Re: **Storage Facility**
Project #: PR-2020-004645
Application #: SI-2023-01803

Please find the following responses addressing comments received in a letter dated November, 29 2023. In an effort to address your comments concisely and simplify your review of these development plans, we have summarized your comments and our responses below. Your comment is listed first, followed by the response in Bold.

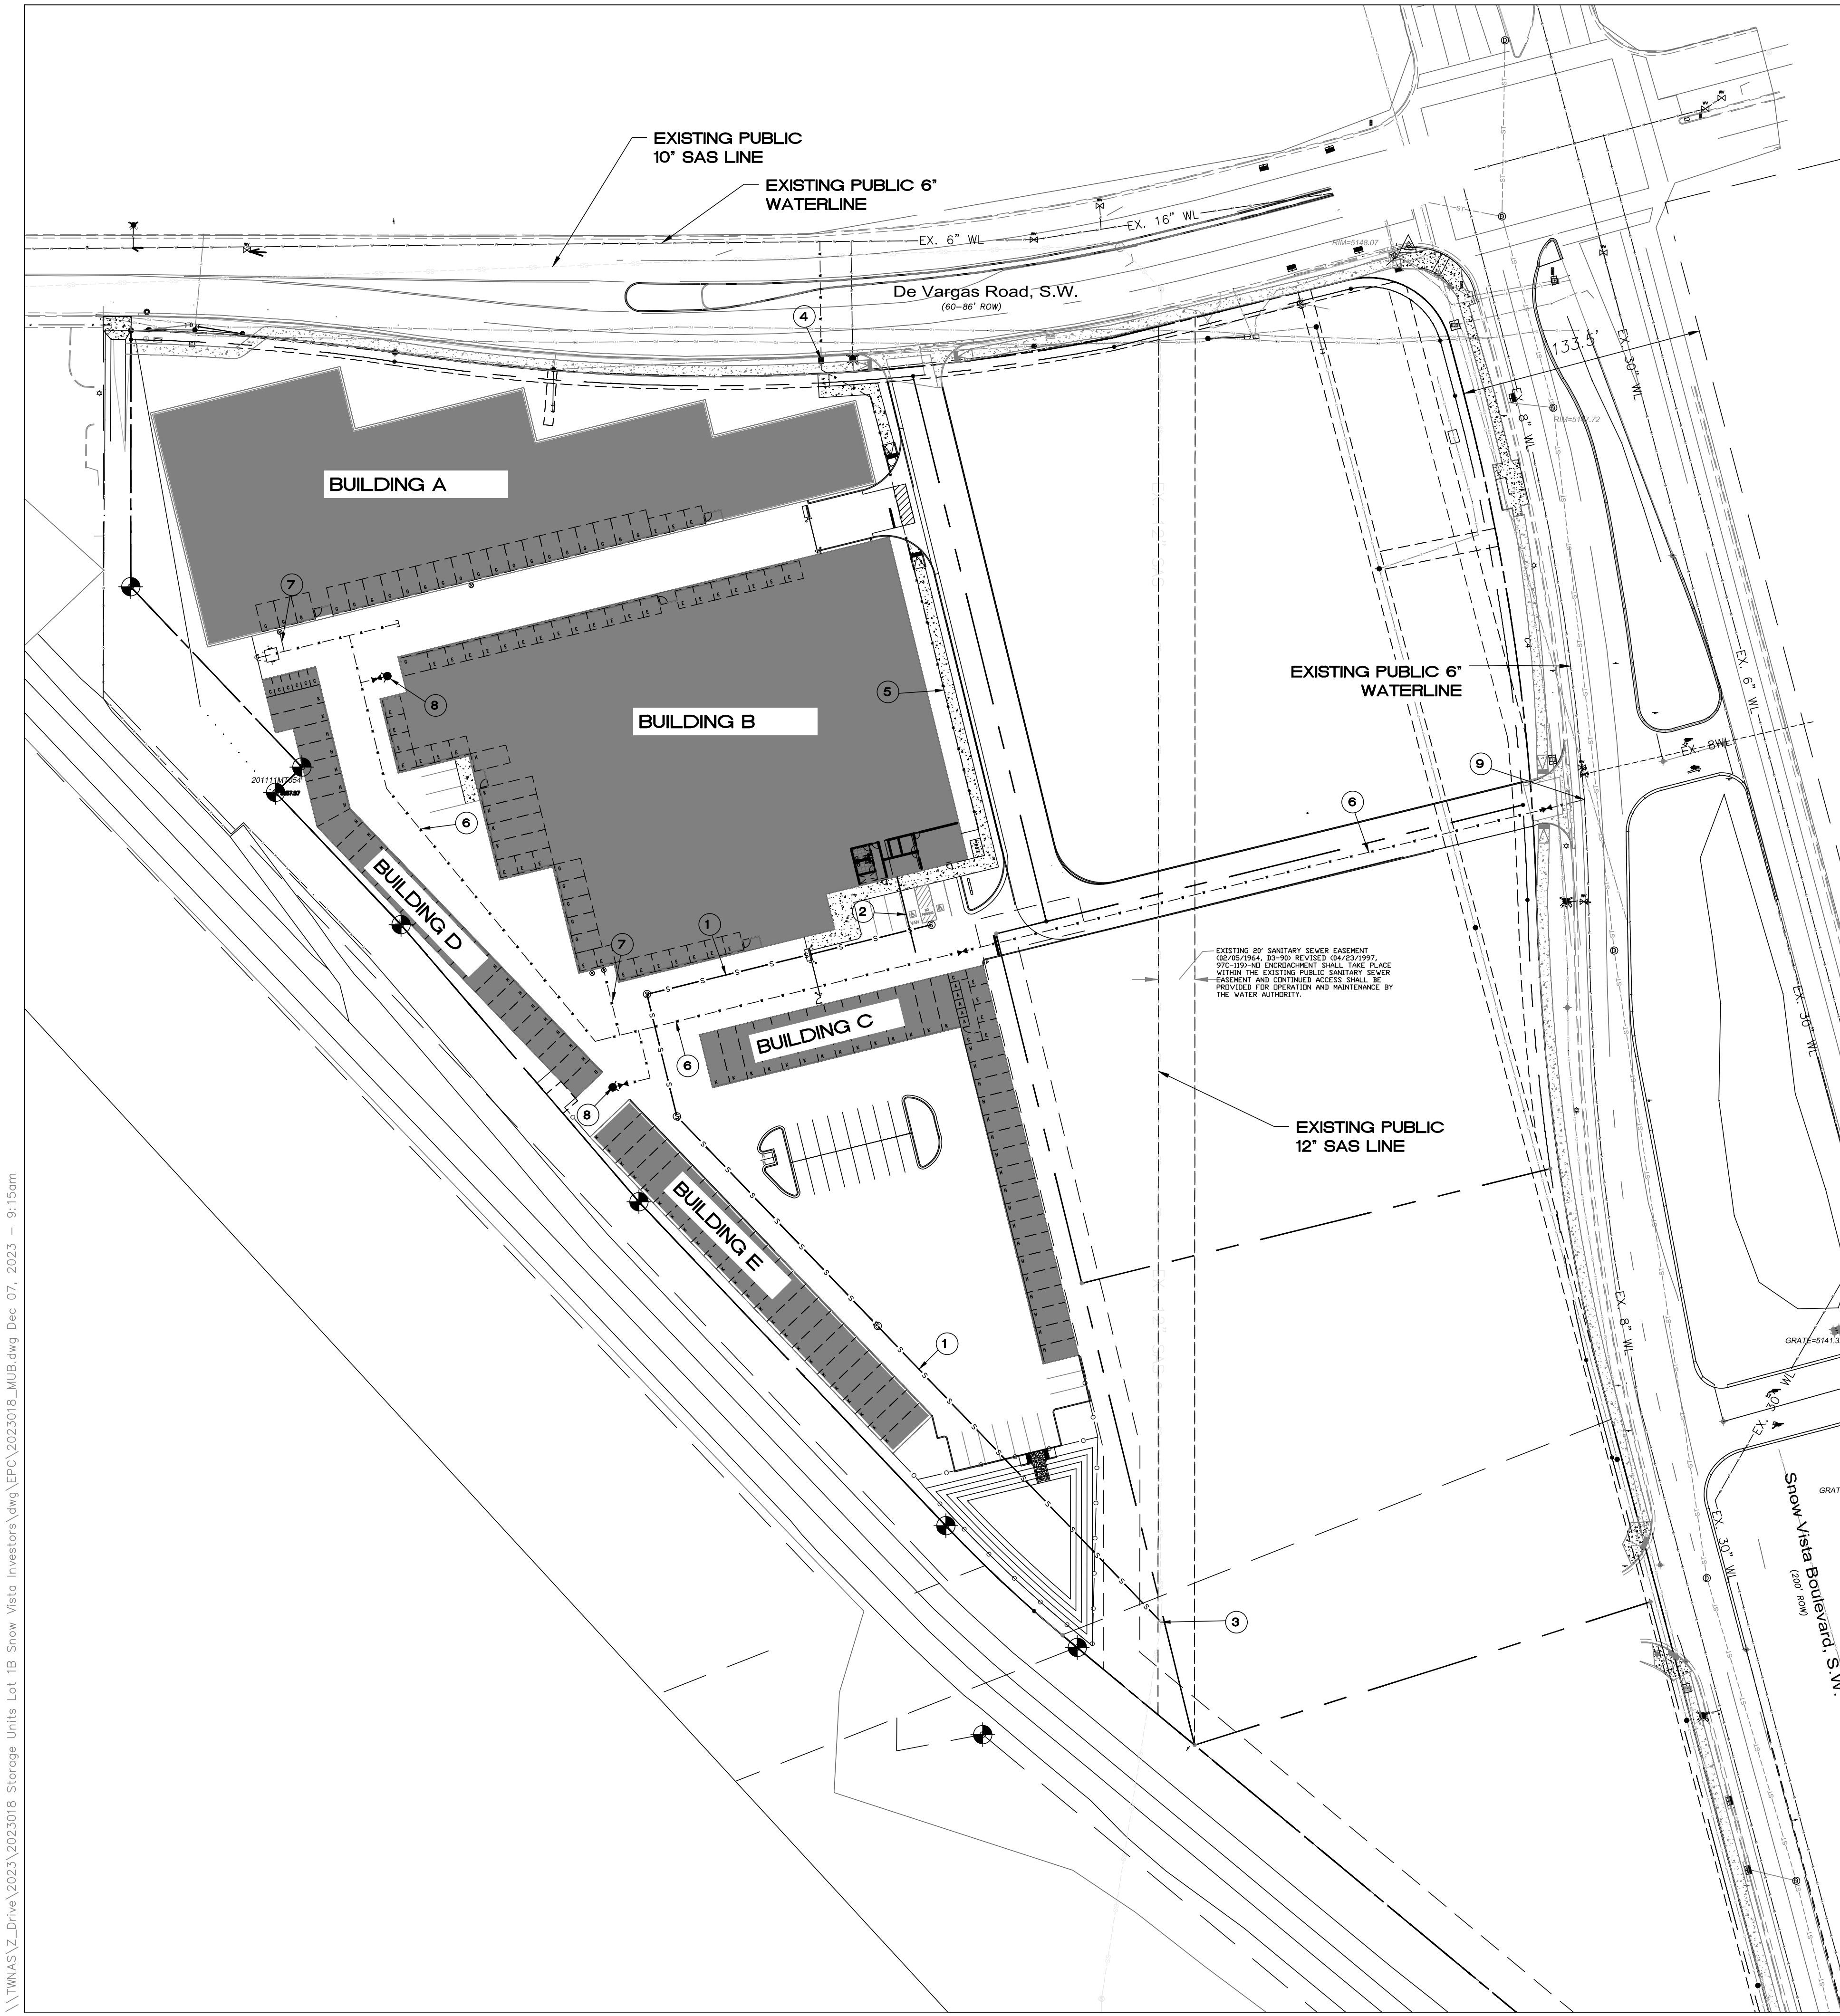
2. Utility Plan:
 - a. Please clearly label public vs. private infrastructure.

- b. Please add the following notes to the Master Utility Plan
 - i. Coordination with Water Authority Cross Connection Section will be required to ensure proper backflow containment is in place prior to release of meter for the site. Contact the Cross Connection Section at 505-289-3454.
 - ii. Coordination with the Water Authority Pre-Treatment Engineer is required to ensure the site complies with Water Authority Sewer Use Ordinance. Contact the Pre-Treatment Engineer at 505-289-3439.

- c. Please clearly show and label the existing easement for the public sanitary sewer line crossing through the site. Also label this as public.

Response: Existing public lines labeled, proposed on-site infrastructure is labeled as private.

Response: Noted added to Utility Plan.

Response: Easement and label added.

Sheet Title:
Planting Plan
 Sheet Number:
LS-01

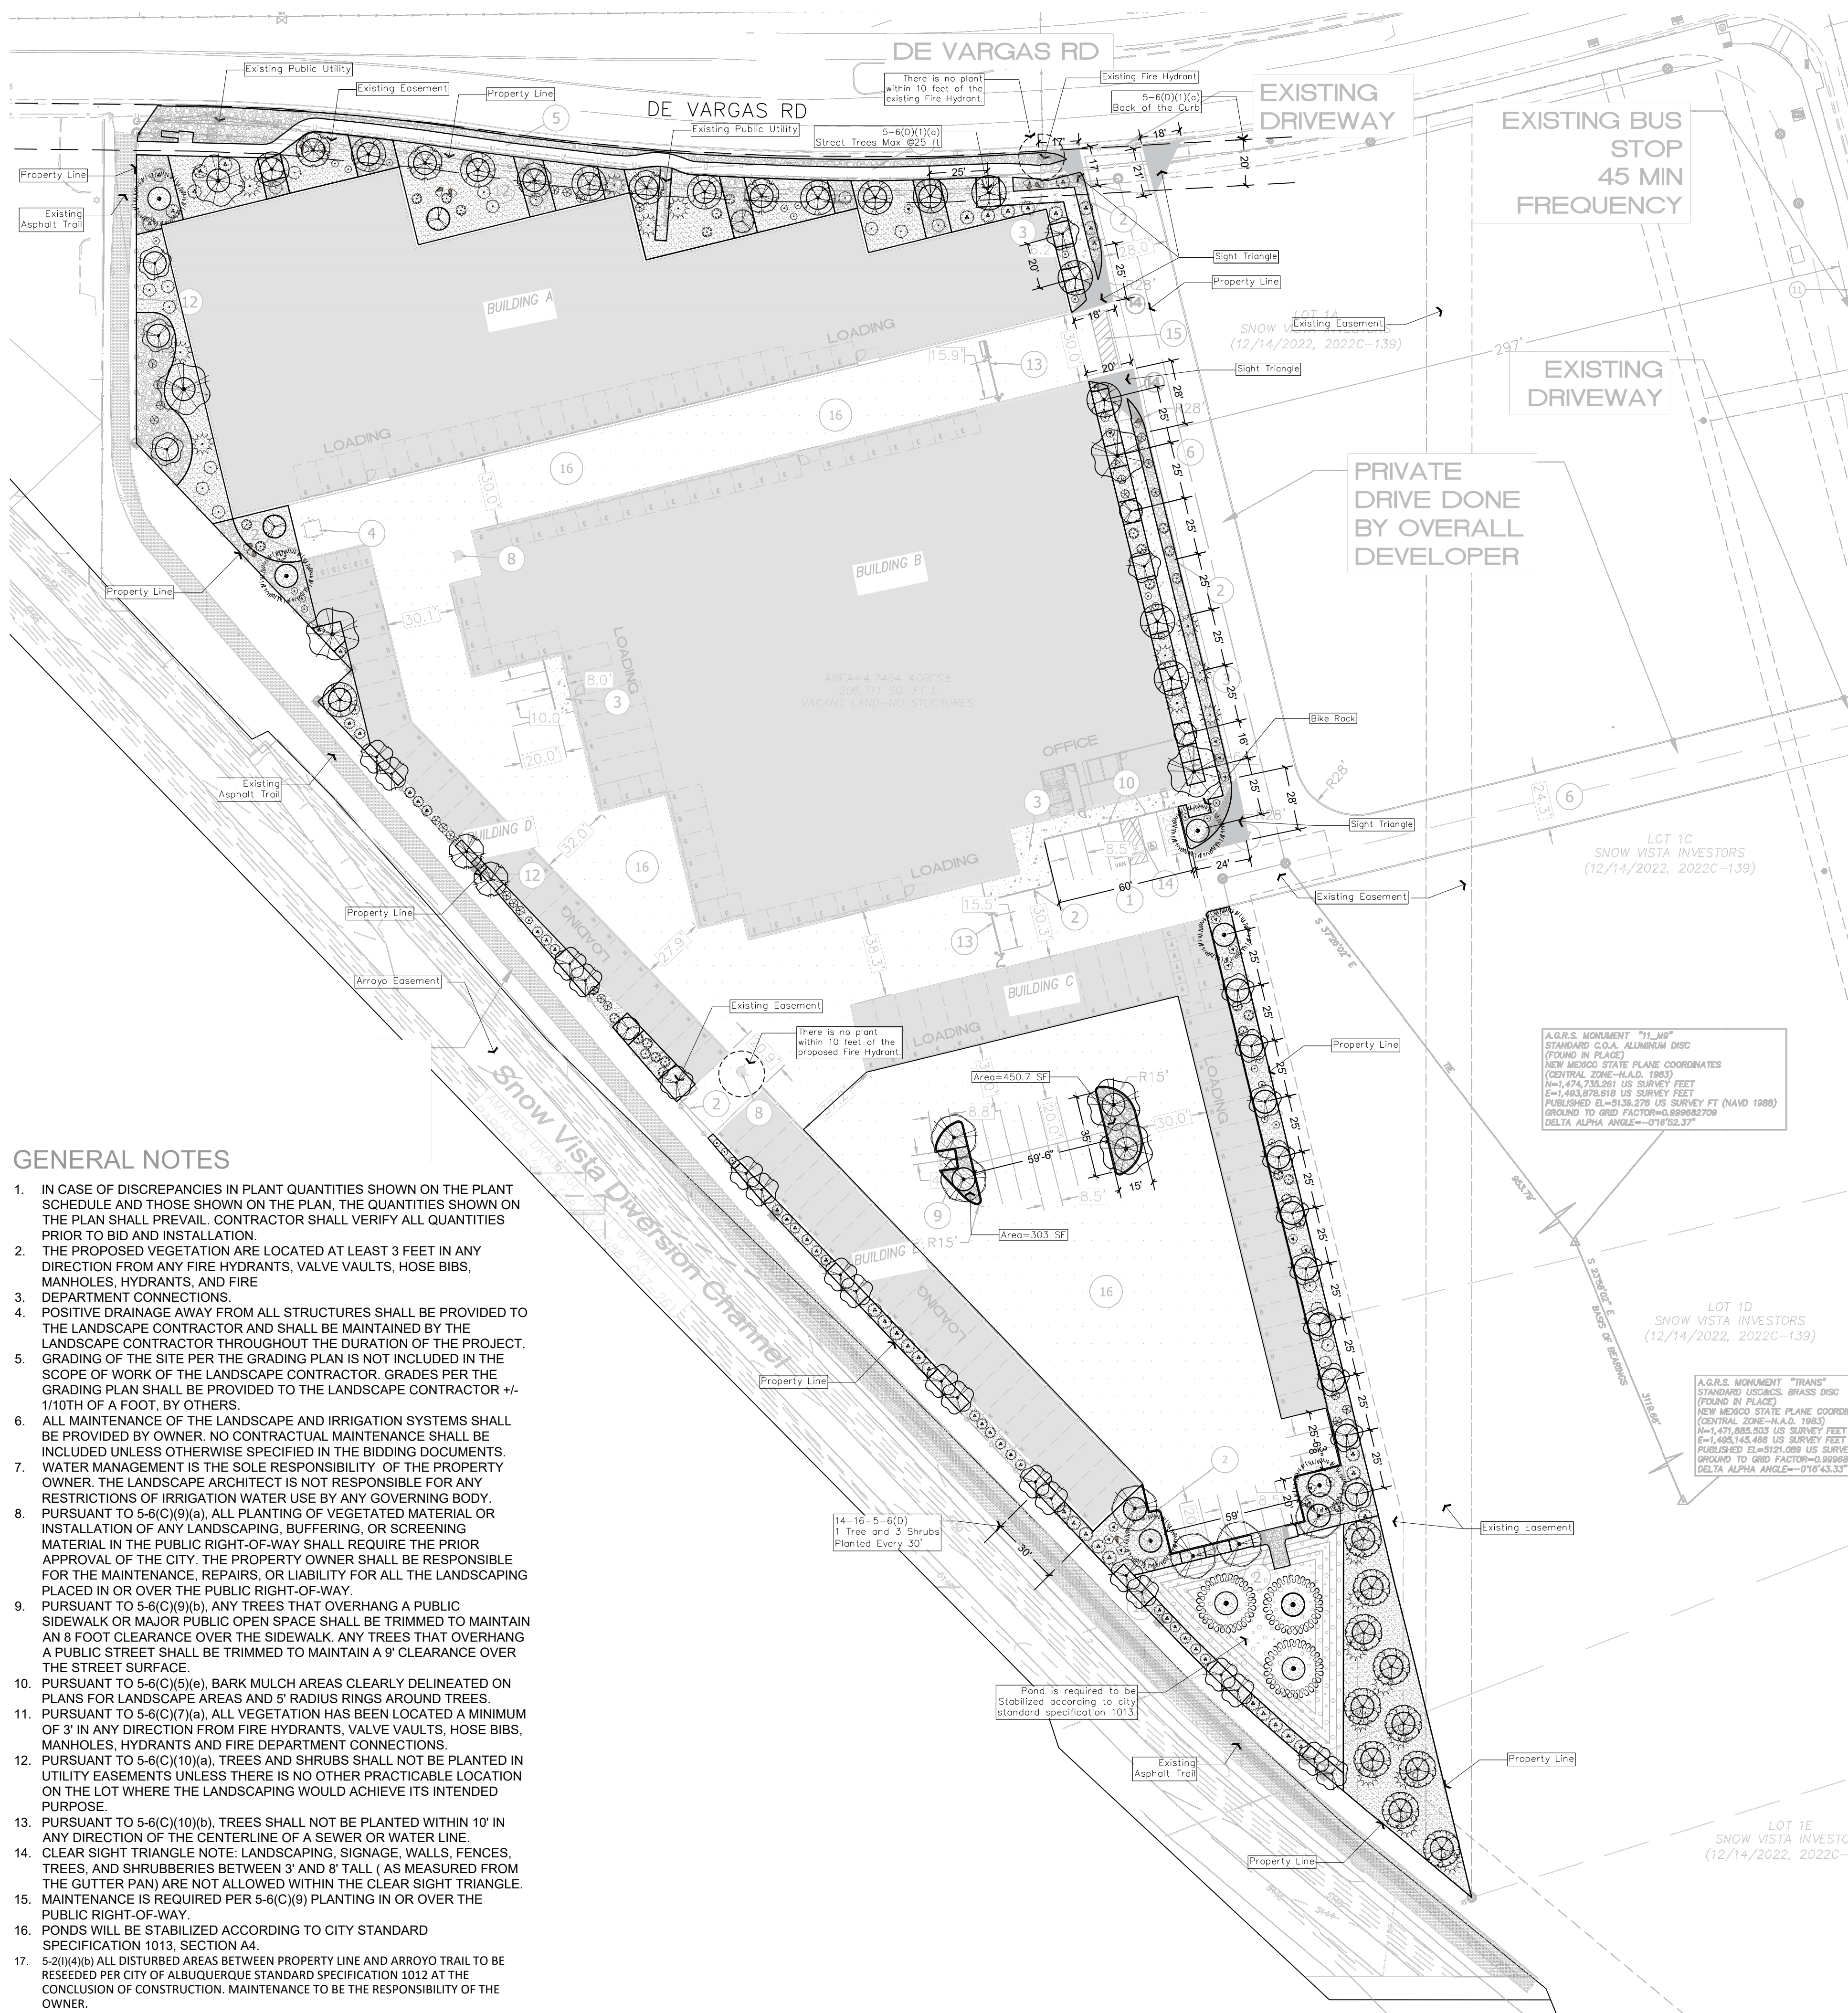
Show dimensions of spacing between trees on walkway on the east side of Building B.

Detail provided on Landscape Plan (LS-01) does not indicate radius of mulch under tree, or what material proposed mulch is. Proposed mulch must be organic material. Please see below:

Incorporate stormwater management areas on the Landscape Plan (LS-01). A ponding area is being proposed at the south side of the subject property. Refer to City of Albuquerque Specifications Section 1013 Slope Stabilization and seeding for landscape requirements at ponding area. Drainage Ponds Slope Stabilization and Seeding Requirements.pdf (cabq.gov) Add a note to the Infrastructure list that ponds will be stabilized according to City Standard Specification 1013.

Provide landscape calculations to ensure this requirement is being met.

Provide dimensions to ensure this requirement is being met.

Show calculations to ensure this requirement is being met.

Provide square footage of tree planters provided for parking lot landscape requirements to ensure this requirement is being met.

YL: Tree spacing along pedestrian path east of building B is now shown on LS-01.

YL: Plan and material legend on LS-01 has been updated to indicate the required mulch ring.

YL: Ponding area now incorporated into landscape plan. Slope stabilization and seeding noted on plan material legend and Note 16, General Notes.

YL: Additional landscaping now included in interior parking on the plan and included in Landscape Data calculations to meet this requirement as well as note 21 below.

YL: New landscape areas added in parking lot interior and dimensions shown.

YL: Calculation added to LS-01 landscape data.

YL: Calculation added to LS-01 landscape data.
